TILBURY 2- NSIP LANDSCAPE AND VISUAL ASSESSMENT CONSULTATION EXERCISE

1. Draft Scoping Stage –March 2017

4. Draft PIER Consultation -July 2017

5. Draft Environmental Statement-September 2017

VIEWPOINT 44 - EXISTING VIEW

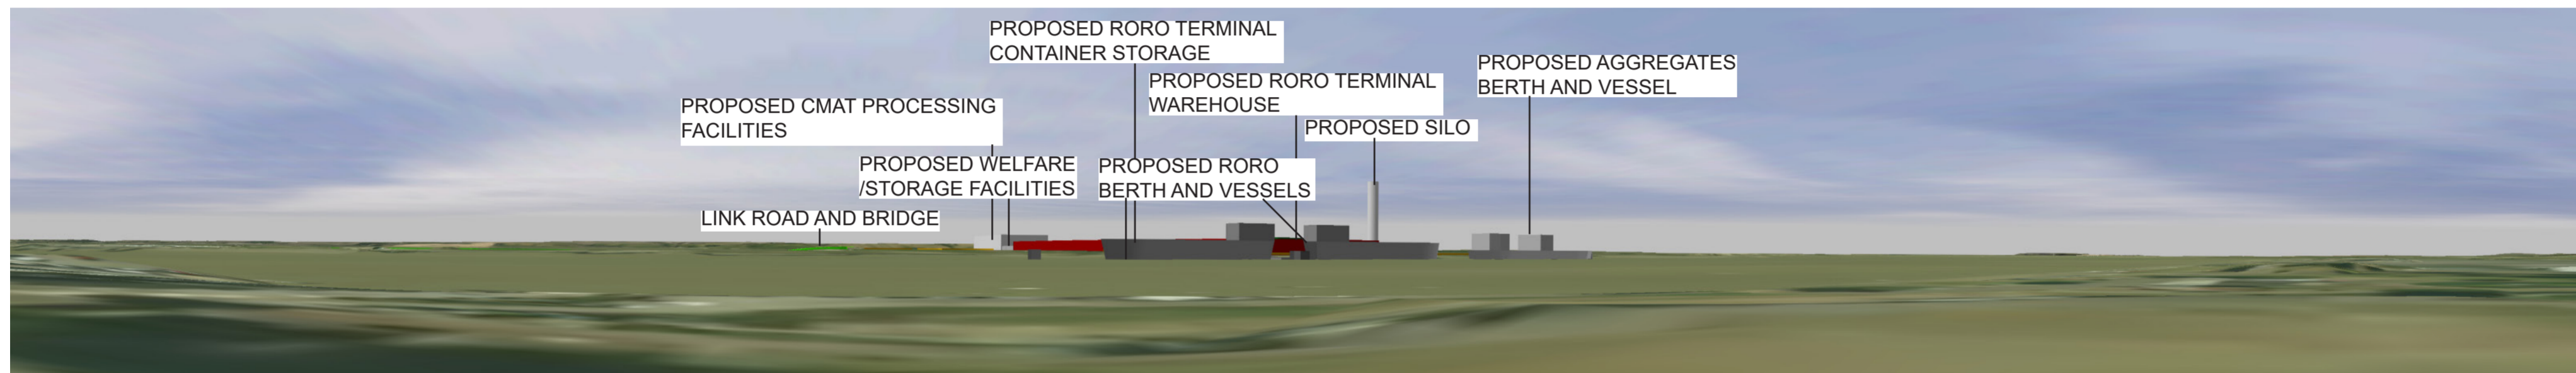
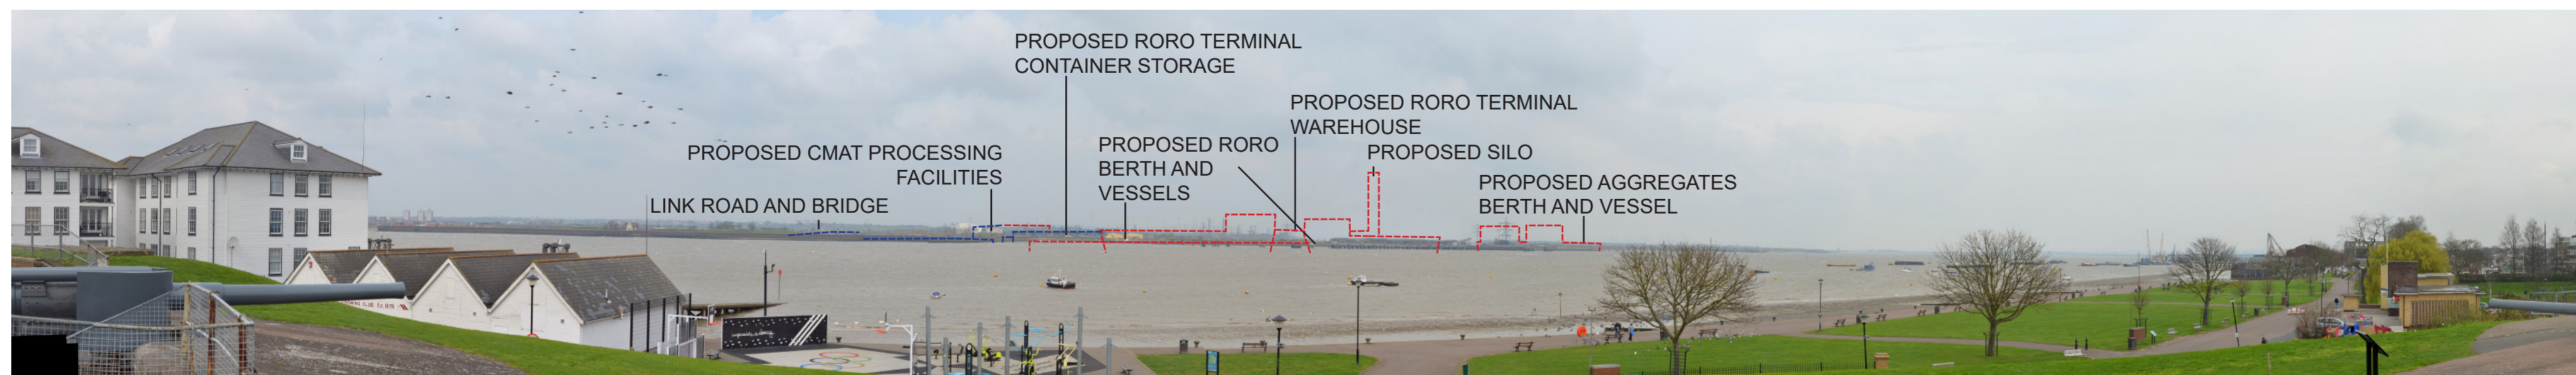
Visualisations: The predicted visual effects visualisations show only one ship moored whereas the ro-ro will accommodate two at any one time, in which case worst case scenario should be shown (viewpoints 44, viewpoint 59).
